National Infrastructure
Planning
Temple Quay House
2 The Square
Bristol, BS1 6PN

Our Ref: TR010063

Application by Gloucestershire County Council for an Order Granting Development Consent for the M5 Junction 10 Improvements Scheme

Advice following issue of decision to accept the application for examination

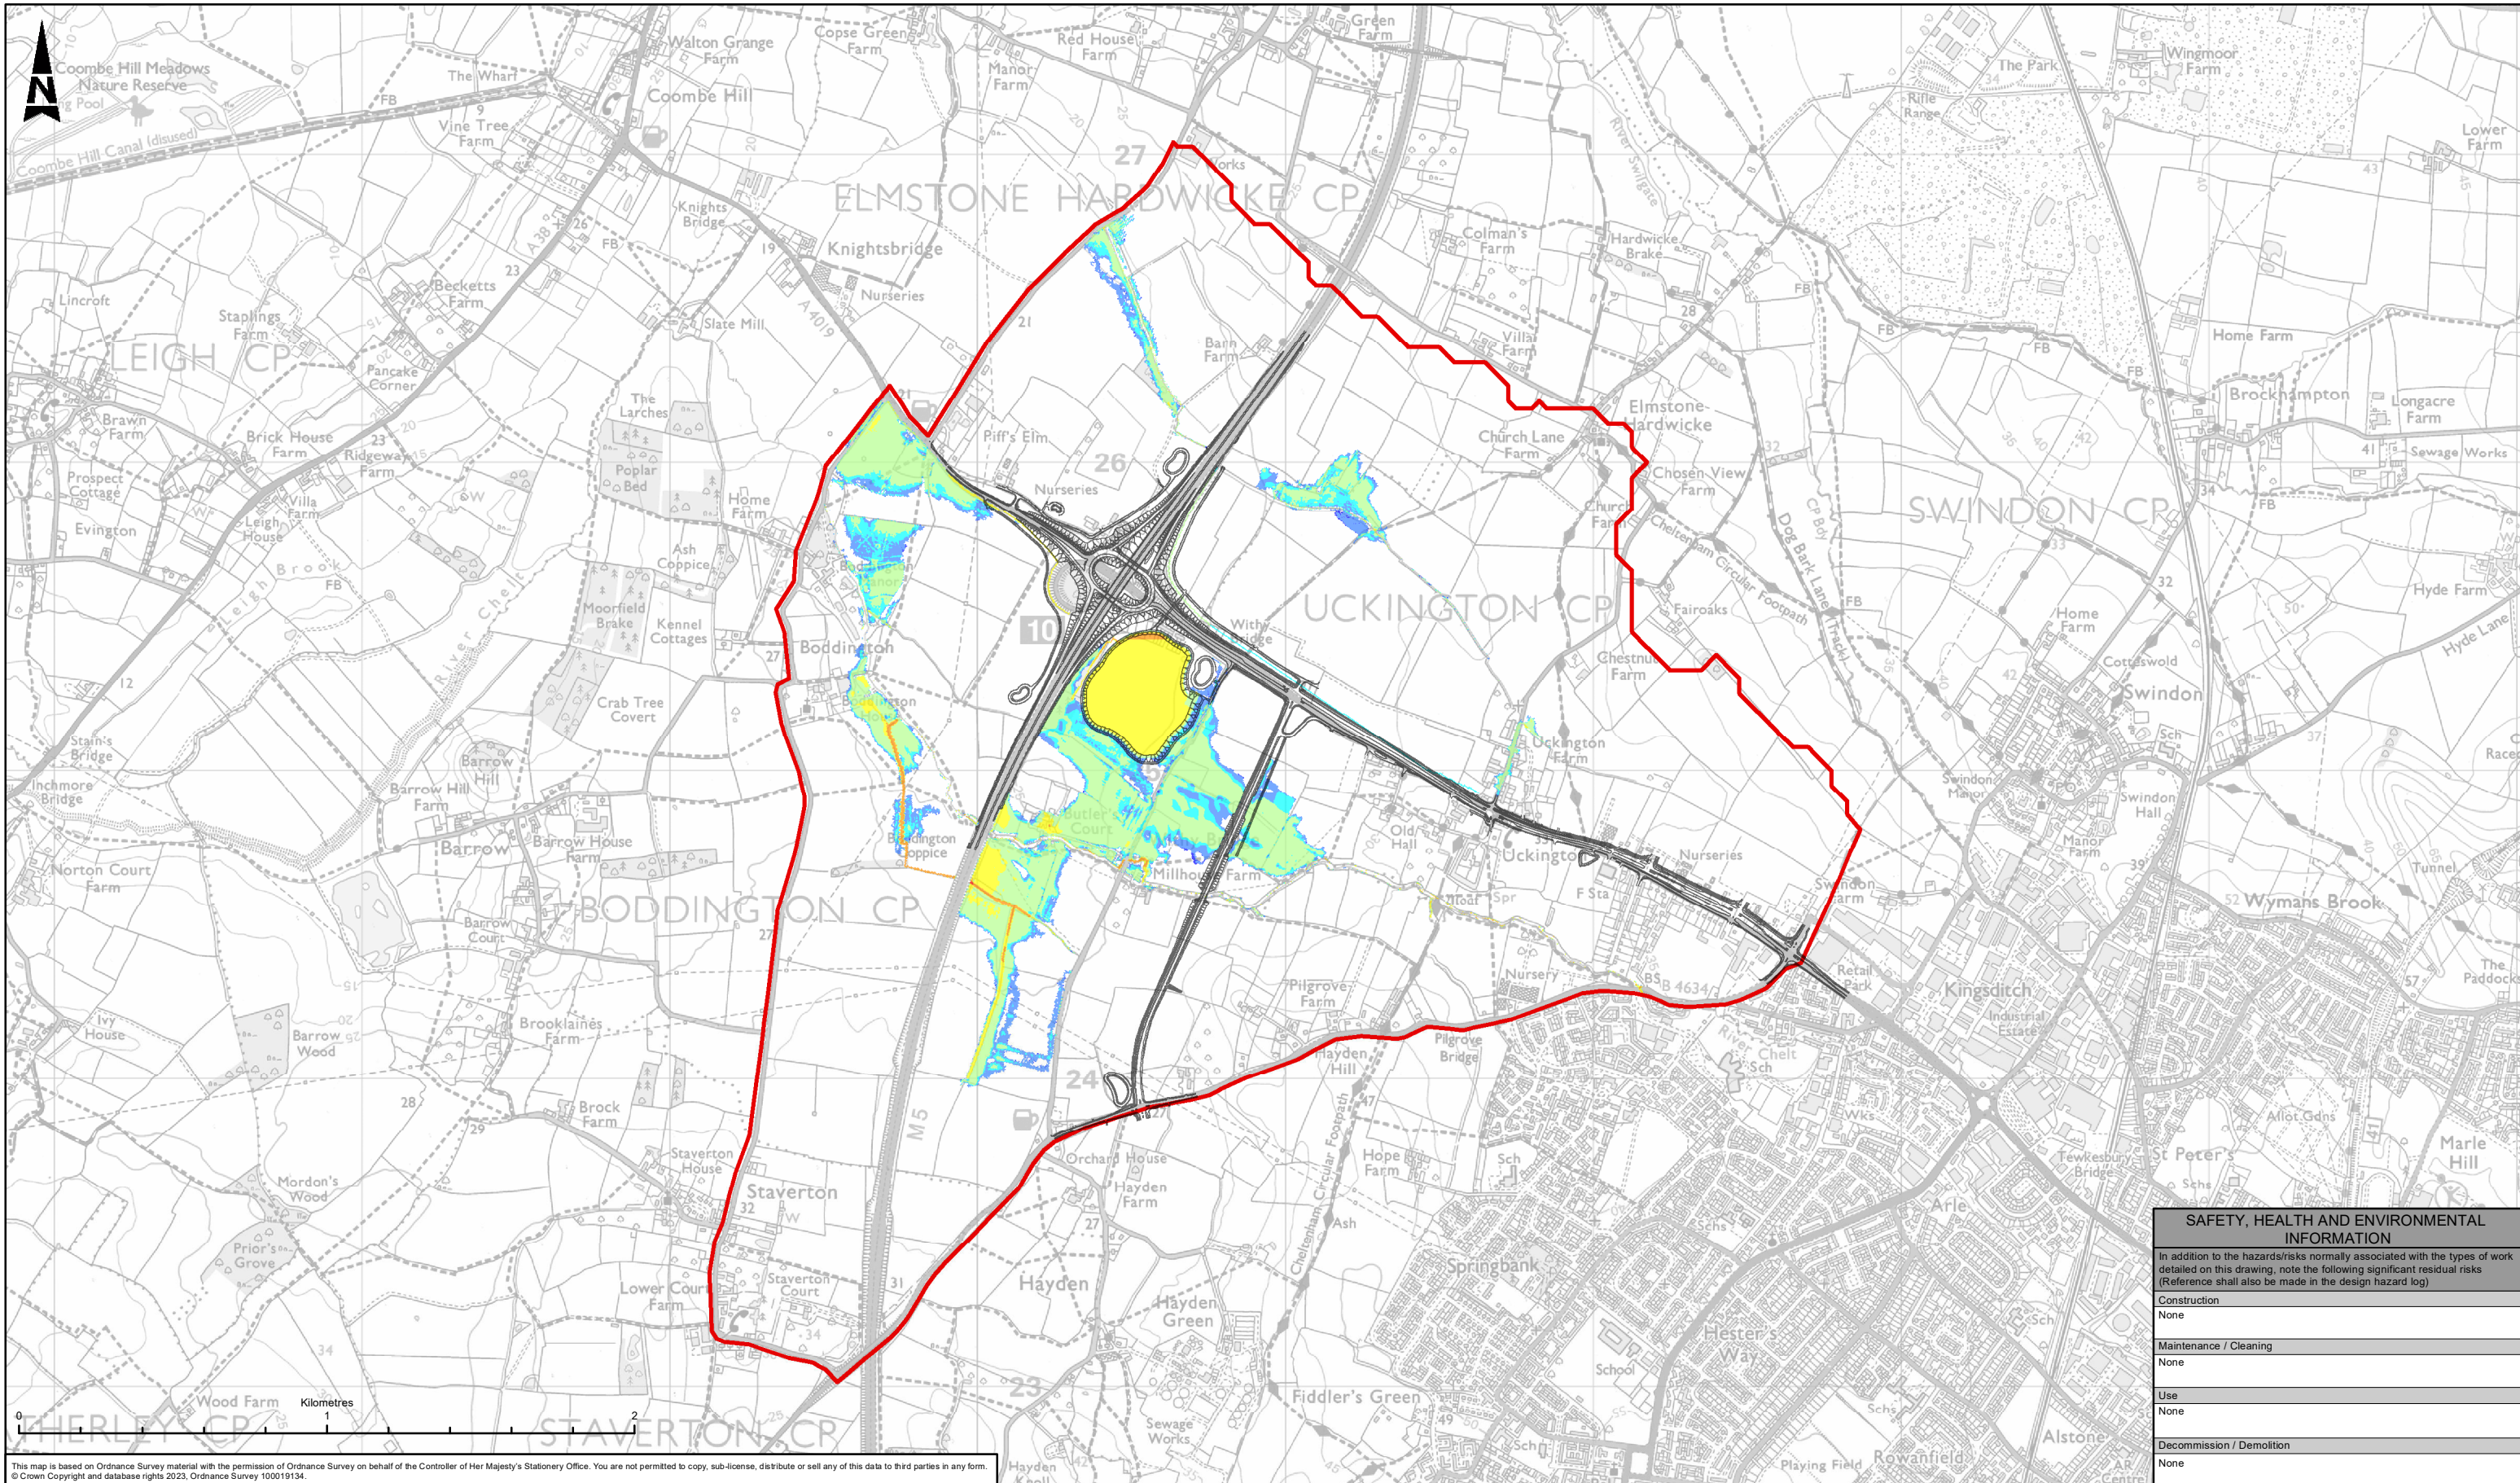
The figures in ES Appendix 8.1B skip from 3-4 to 3-7 and 5-1 to 5-4. It does not appear that any are missing as the contents page appears to indicate that the Applicant did not use the intervening figure numbers; however, the Applicant is advised to confirm this.
